Recommendation Report for Planning Permission for Works or Extension to a Dwelling

REF NO: LU/147/15/HH

LOCATION: 34 Arundel Drive
Thornlea Court
Littlehampton

PROPOSAL: Porch to existing static home. This application may be determined by Littlehampton Town Council under delegated powers.

Proposed west elevation. Scale 1:100

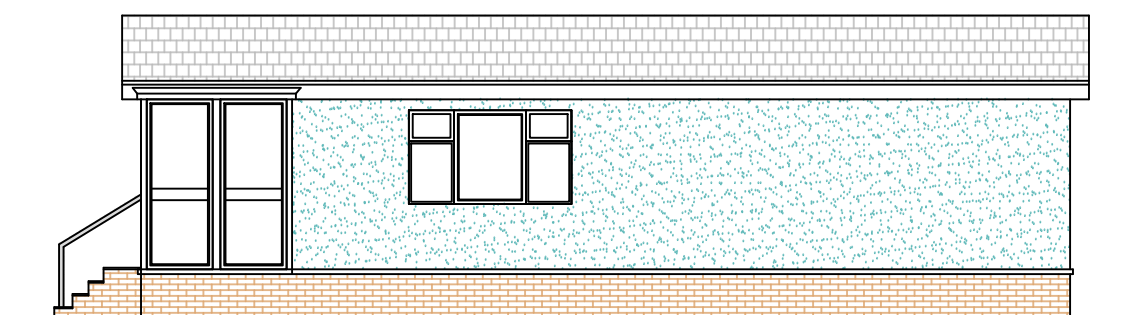
The proposed porch extension will measure 0.85 metres in width with a depth of 2 metres - it will be located on the western elevation of the property and is considered to appear subservient and integrated with the host dwelling. The proposal is also not considered to unacceptably impact upon the established character of the area.

The proposed porch is therefore considered to be in accordance with policies GEN7 (ii) and DEV19 (i), (ii) & (v) of the Arun District Local Plan.
